Outer Dowsing Offshore Wind

Schedule of Changes to the Draft Development Consent Order

Date: July 2024

Document Reference: 3.1.1

Drawing: 3 of 5 Page Size: A1

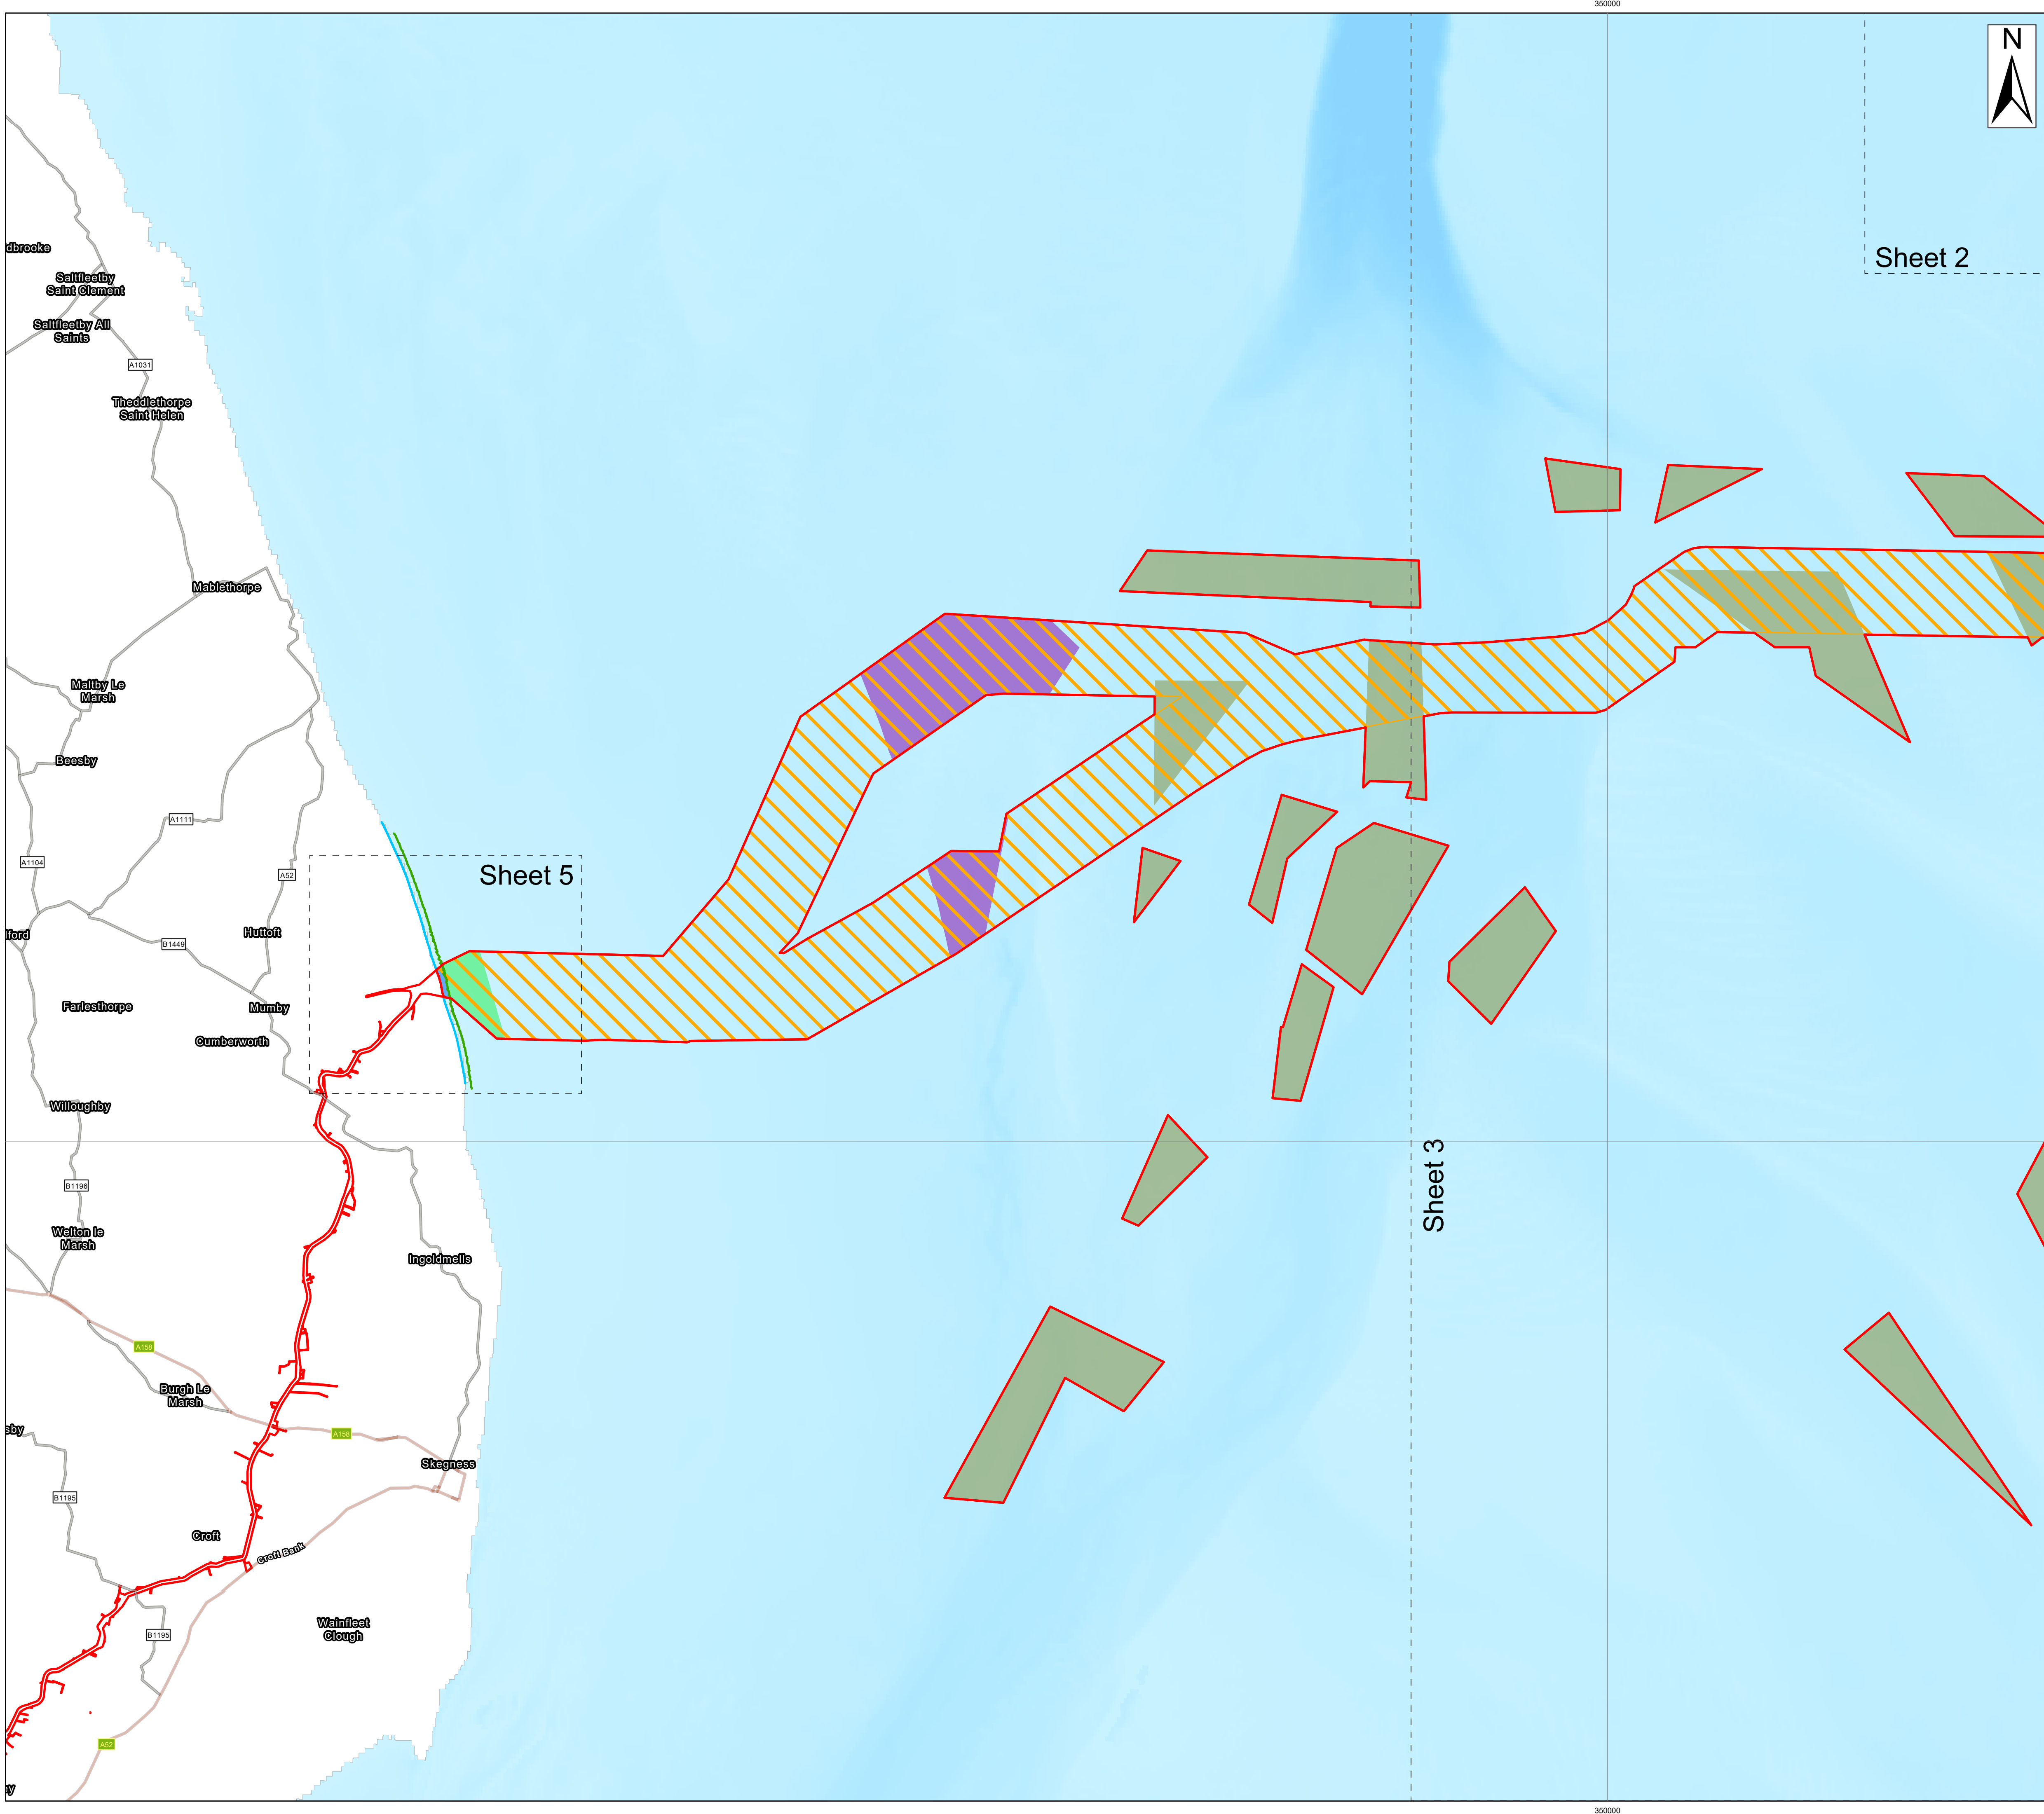
Schedule 1				
Schedule 1, Part 1, Paragraph 2	Applicant	The Offshore Order Limits and Grid Coordinates Plan (document reference 2.8) has been updated to reflect the updated position of the mean low and mean high water marks. As a result, the grid co-ordinates specified within the Draft DCO have been updated.	Grid coordinates updated.	2
Schedule 1, Part 3, Requirement 13(3)	Applicant	In reviewing the Draft DCO, the Applicant identified an incorrect reference to Work No. 14 (transition joint bays) within sub-paragraph (3) which should have been a reference to	<i>(3) Any approved permanent fencing in relation to the onshore transmission works in Work No. 1614 must be completed before those works are brought into use and must be maintained for the operational lifetime of the onshore transmission works in Work No. 1614.</i>	2
